DOC21/680335-31
2 September 2021

EPA Advice on Environmental Impact Statement

Thank you for the request for advice from Public Authority Consultation (PAE-25647096), requesting the review by the NSW Environment Protection Authority (EPA) of the Environmental Impact Statement for the proposed Modification Application to increase in depth of mining (MP09_0182-Mod-8) at Boggabri Coal Mine, 386 Leard Forest Road, Boggabri NSW 2382.

Figure 5 | Indicative noise contours – Year 2027

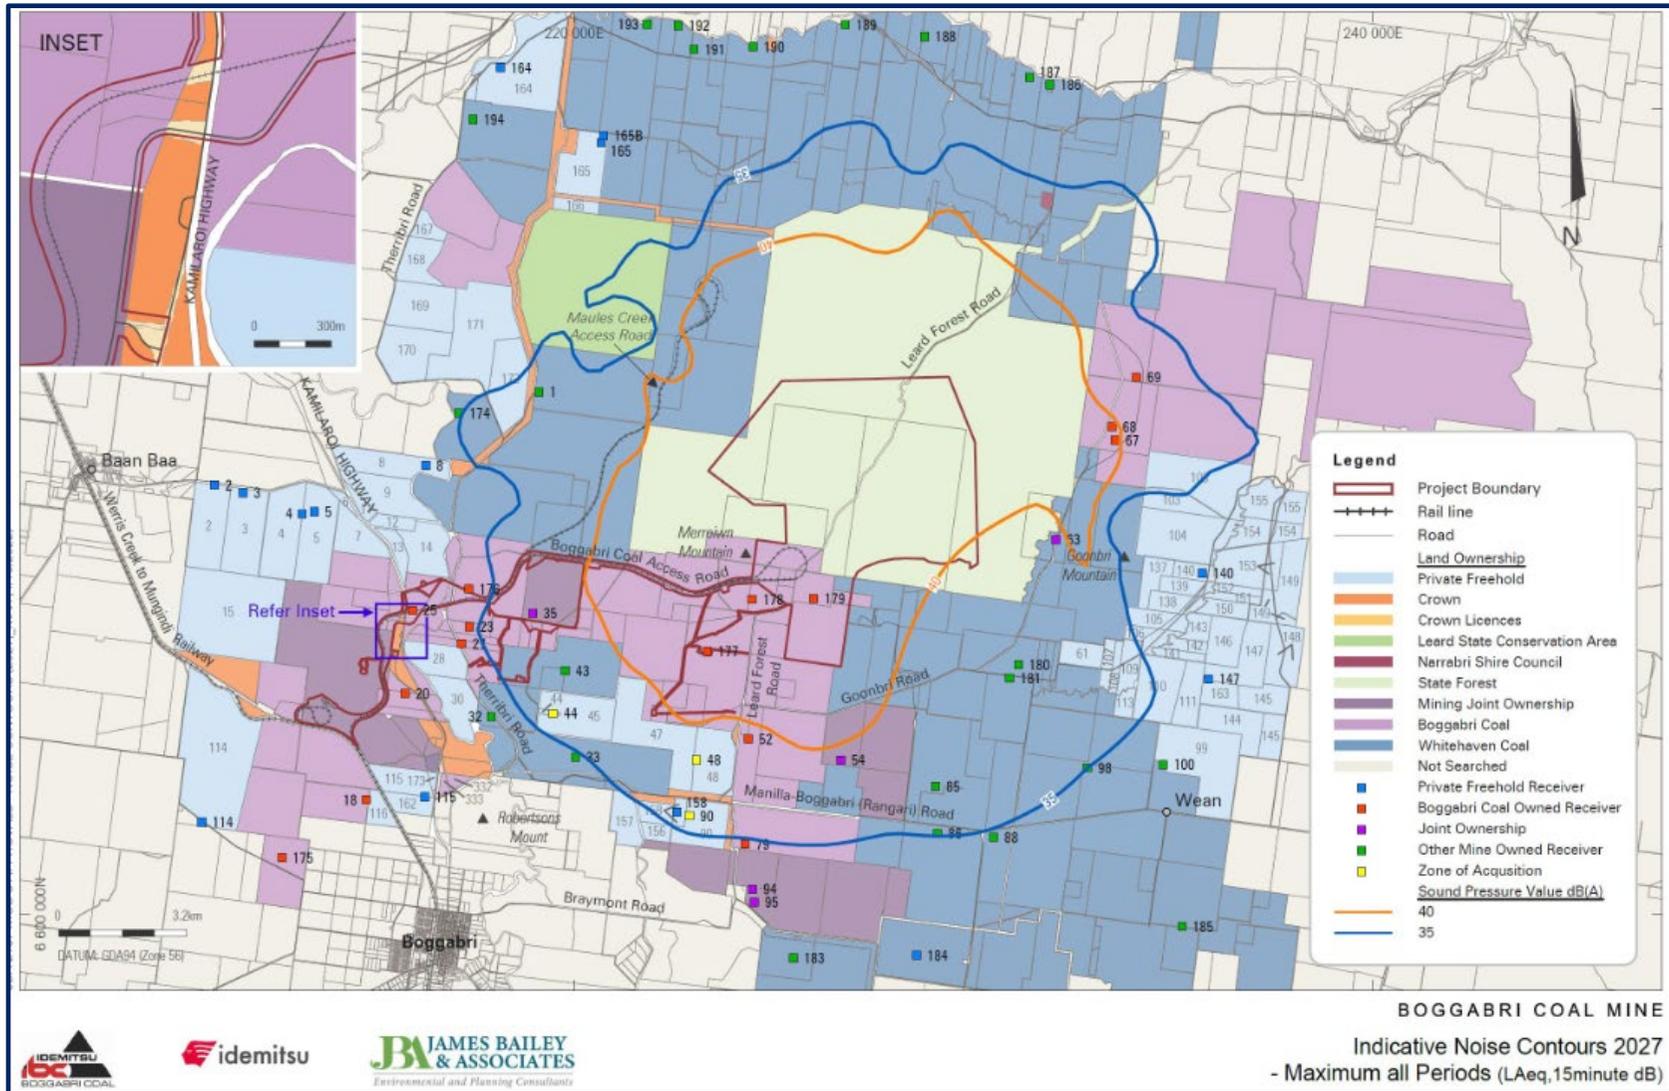
The EPA recommends that Planning should consider the implications for noise levels exceeding LAeq,15 min 35dB at receivers 8 and 158, with respect to the SSD 09_0182 Schedule 3, Condition 6 requirements.

The noise modelling (which did not include drainage flow, as above) has demonstrated that exceedance of currently applied limits will occur at 3 locations as identified below:

Location	Exceedance	Comment
48	+1dB at night resulting in a noise levels of LAeq,15min 39 dB	This location is currently subject to voluntary acquisition in SSD 09_0182 and hence has not been further considered.
8	+1dB at night resulting in a noise levels of LAeq,15min 36 dB	This location was assessed as compliant with LAeq,15min 35/35/35dB in the original assessment
158	+1dB at night resulting in a noise levels of LAeq,15min 36 dB	This residence was constructed after the mine was determined and was not considered in the original assessment.
